From: [Wolfley, Jolene](#)
To: [Phelan, Whitney A.](#); [Hendricks, Nancy E](#); ron@thegroup.cc; "Adil Rizvi"
Cc: [Aulick, Hannah](#); [Rodenbeck, Jay B.](#)
Subject: Need for future meeting: Mojave Subdivision PR 3484
Date: Tuesday, January 21, 2025 1:45:29 PM
Attachments: [image001.png](#)
[image002.png](#)

From: Phelan, Whitney A. <wphelan@cabq.gov>
Sent: Friday, January 17, 2025 3:13 PM
To: Hendricks, Nancy E <Nancy_Hendricks@nps.gov>; ron@thegroup.cc; Wolfley, Jolene <jlwolfley@cabq.gov>; 'Adil Rizvi' <adilr1424@gmail.com>
Cc: Aulick, Hannah <haulick@cabq.gov>; Rodenbeck, Jay B. <jrodenbeck@cabq.gov>
Subject: RE: [EXTERNAL] FW: Mojave Subdivision

From: Hendricks, Nancy E <Nancy_Hendricks@nps.gov>
Sent: Friday, January 17, 2025 2:31 PM
To: ron@thegroup.cc; Wolfley, Jolene <jlwolfley@cabq.gov>; 'Adil Rizvi' <adilr1424@gmail.com>
Cc: Phelan, Whitney A. <wphelan@cabq.gov>; Aulick, Hannah <haulick@cabq.gov>; Rodenbeck, Jay B. <jrodenbeck@cabq.gov>
Subject: Re: [EXTERNAL] FW: Mojave Subdivision

PLAN AT C-C

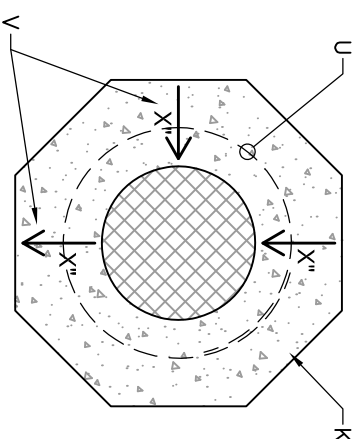
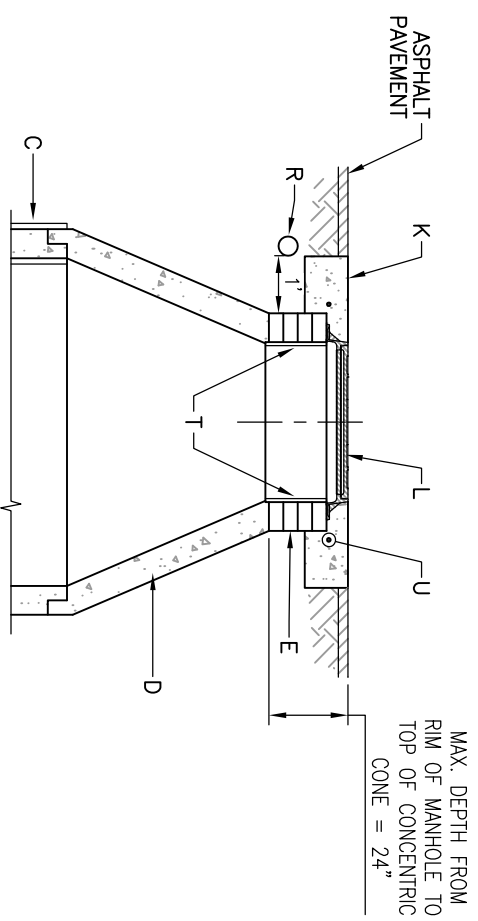
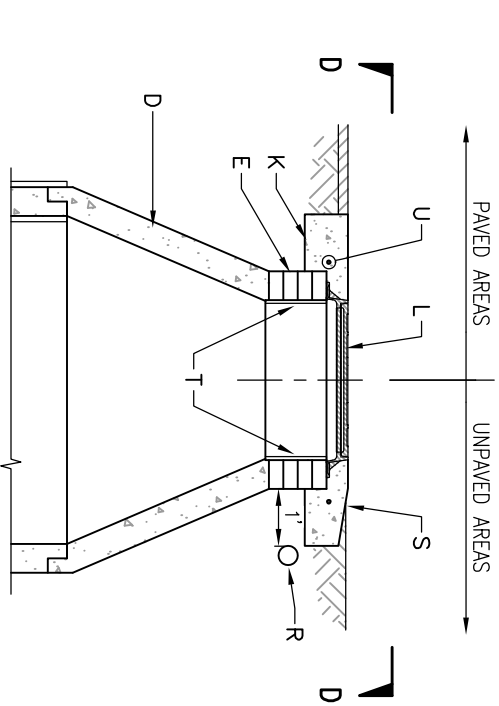
It seems that the connection to the sewer line is straightforward - however we still need additional details that I'm having trouble garnering from the site plan, such as how deep the hole would be and the equipment to be utilized, and access requirements.

**MOJAVE SUBDIVISION**  
 GRADING AND DRAINAGE  
 GRADING PLAN

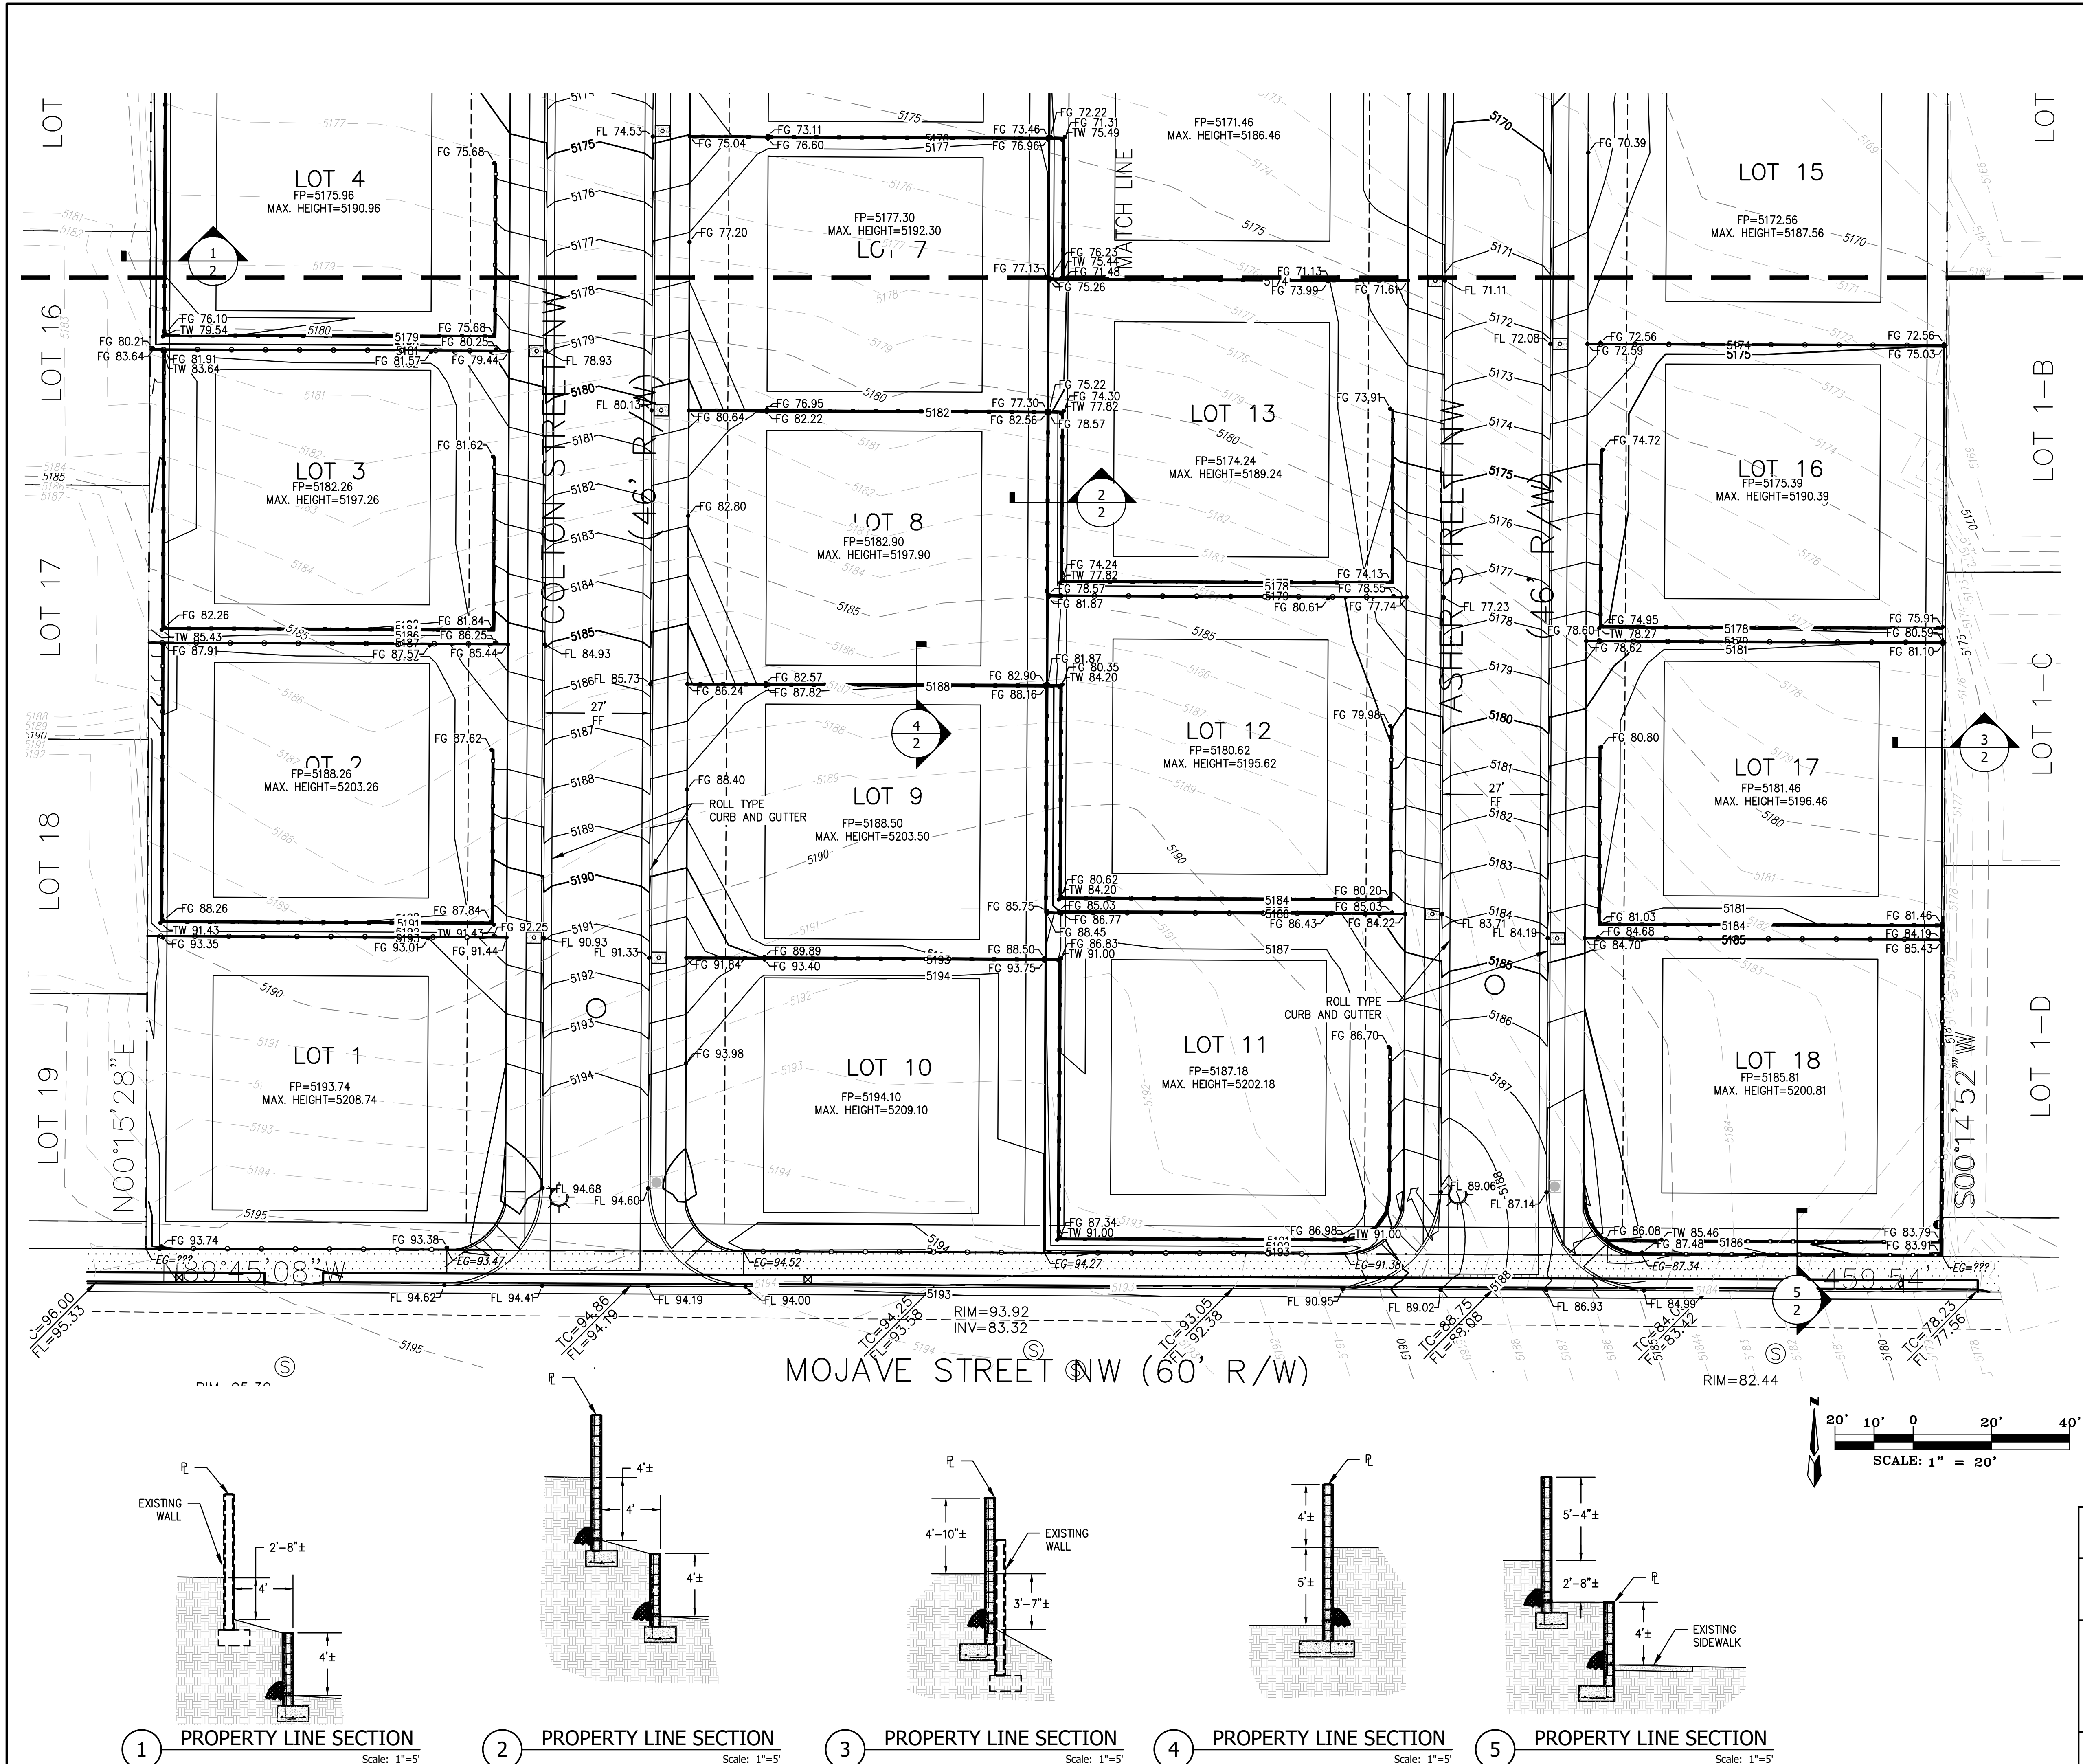
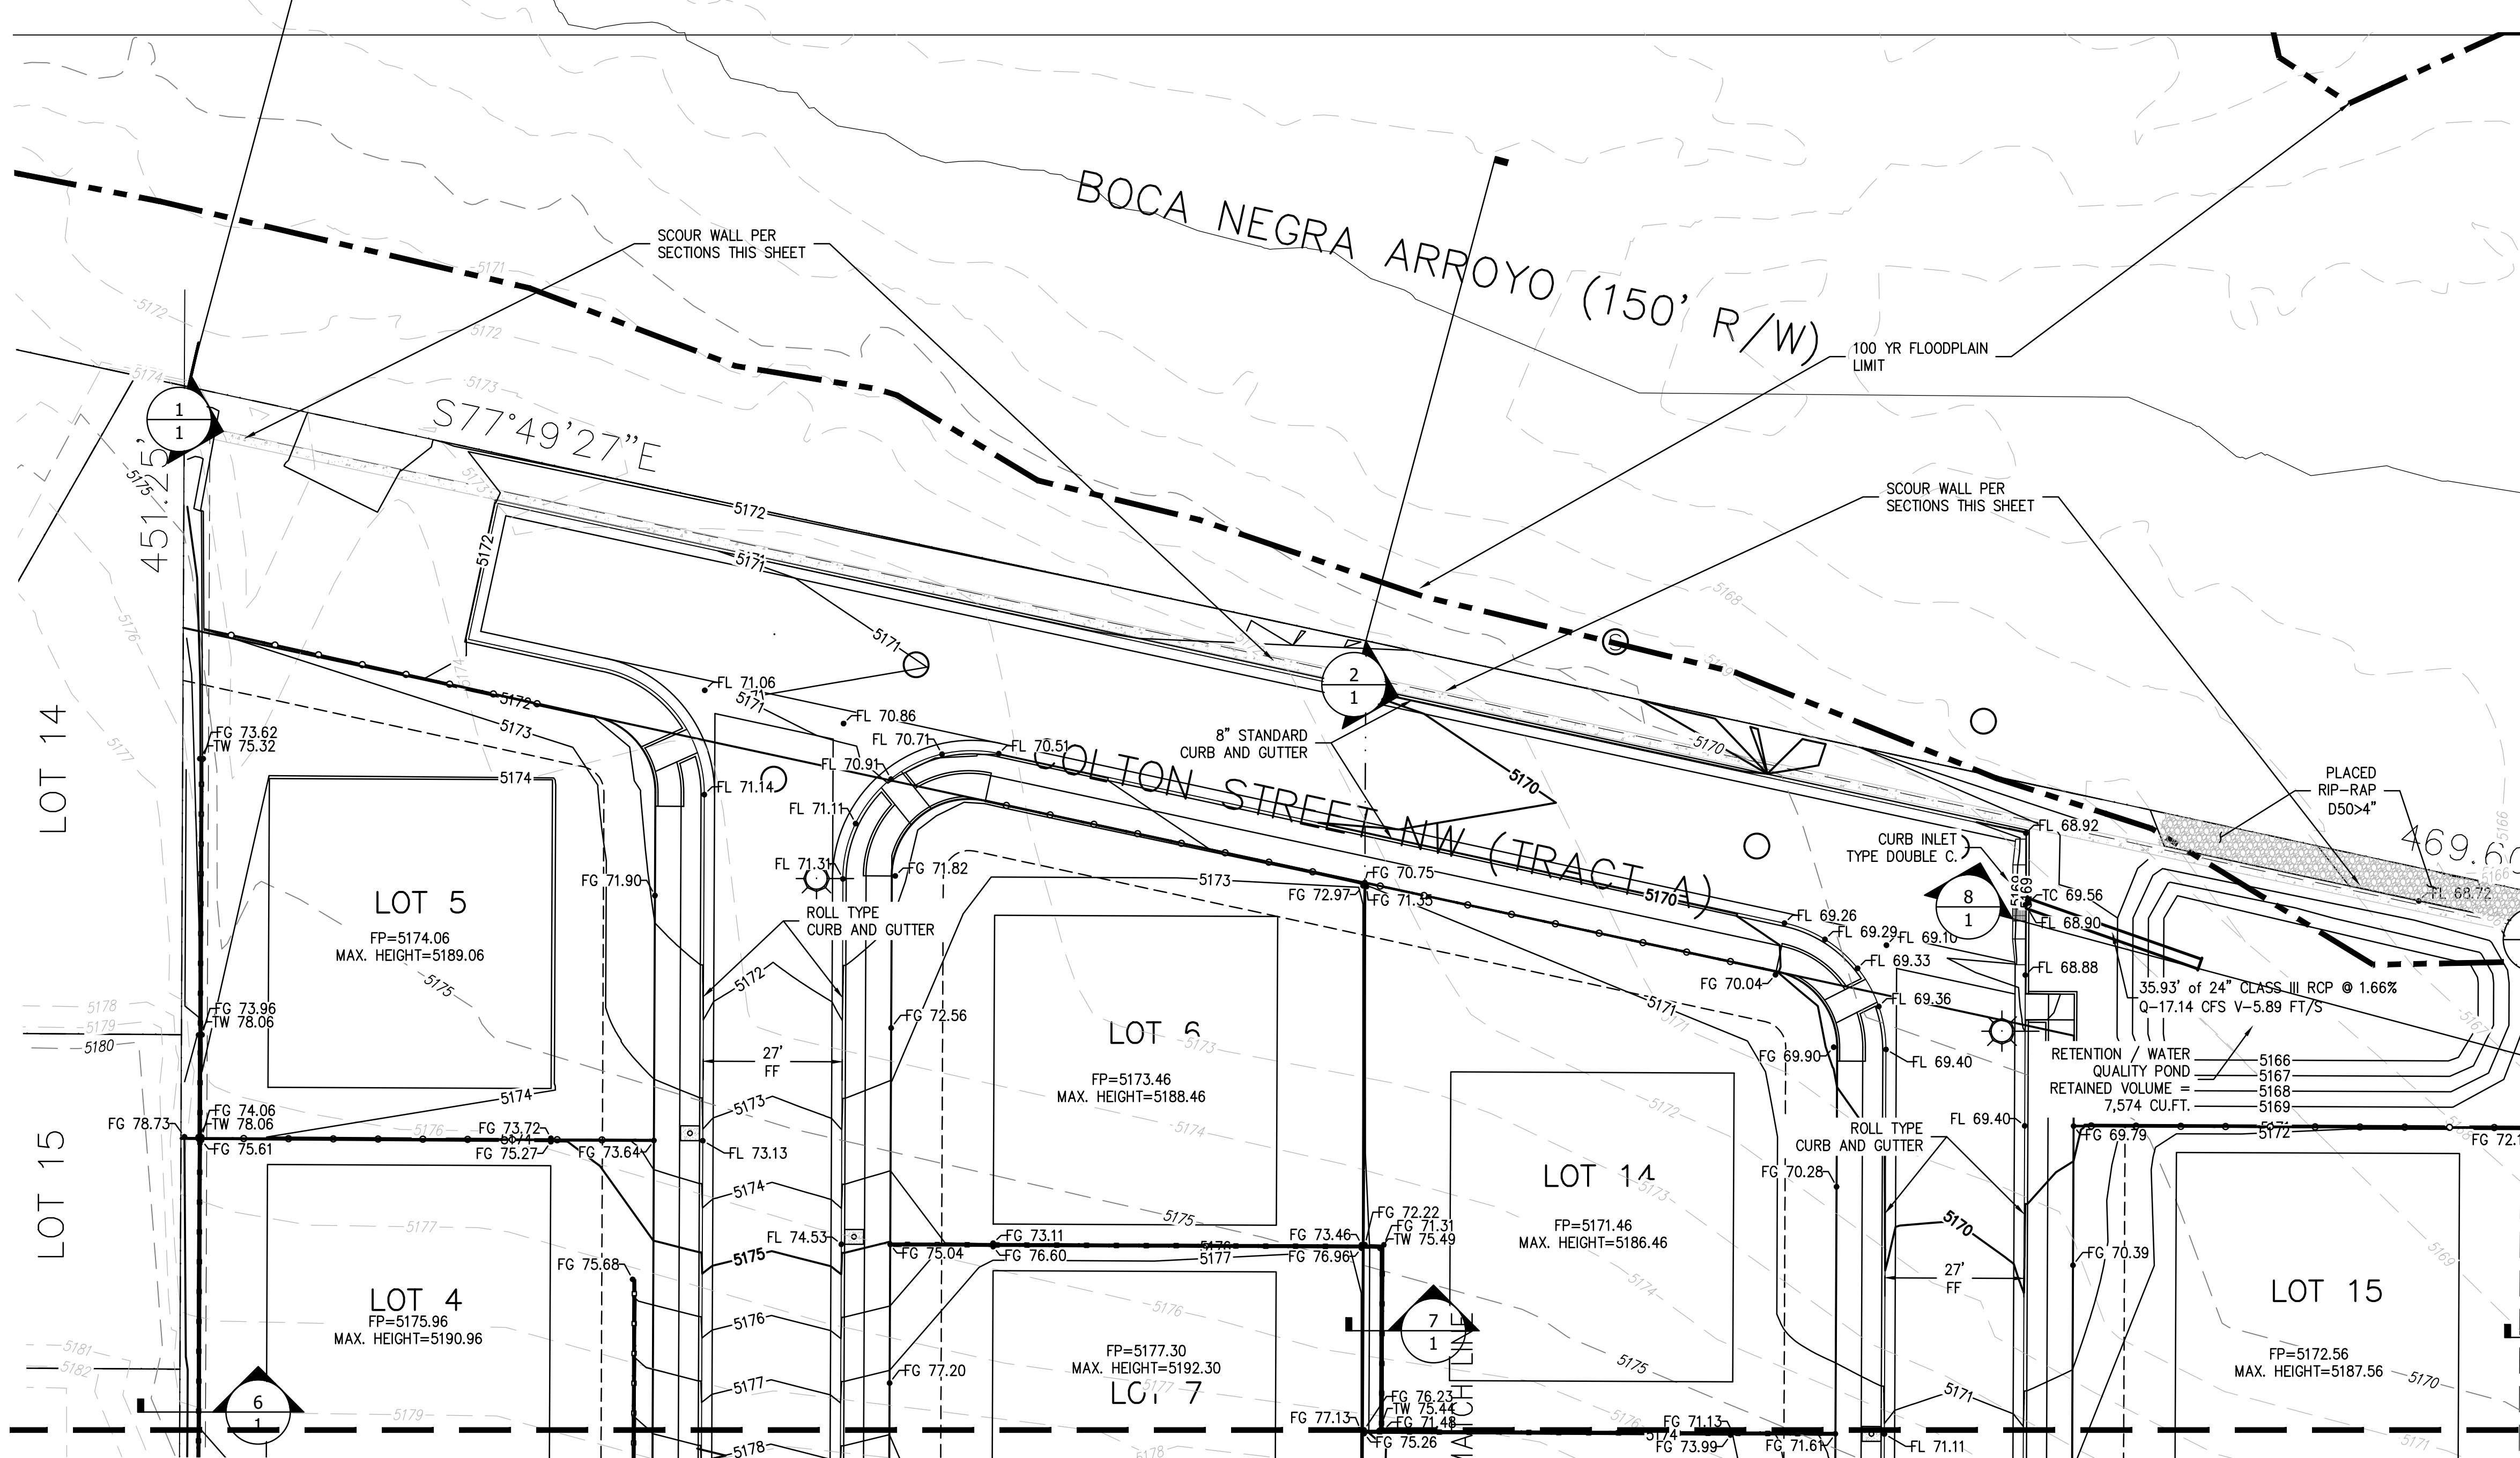
We have a few clarifying questions - about the pond/overflow. It is unclear to me from the site plan how deep it is, and what the overflow plans are - it appears that the overflow would be directed in the Monument. If it is a deep pond (20 feet+) this is likely not an issue, though I'm not a hydrologist so I can't make that a definitive statement. If it is a shallower overflow pond, we are concerned about erosion resulting from directed flows to the outflow area in the Monument and impacts to the arroyo and the adjacent trail.

It would be helpful to understand if the outflow would be stepped out or hardened with rip rap within the development as well and also helpful if the City Engineer/Hydrologists can weigh in.
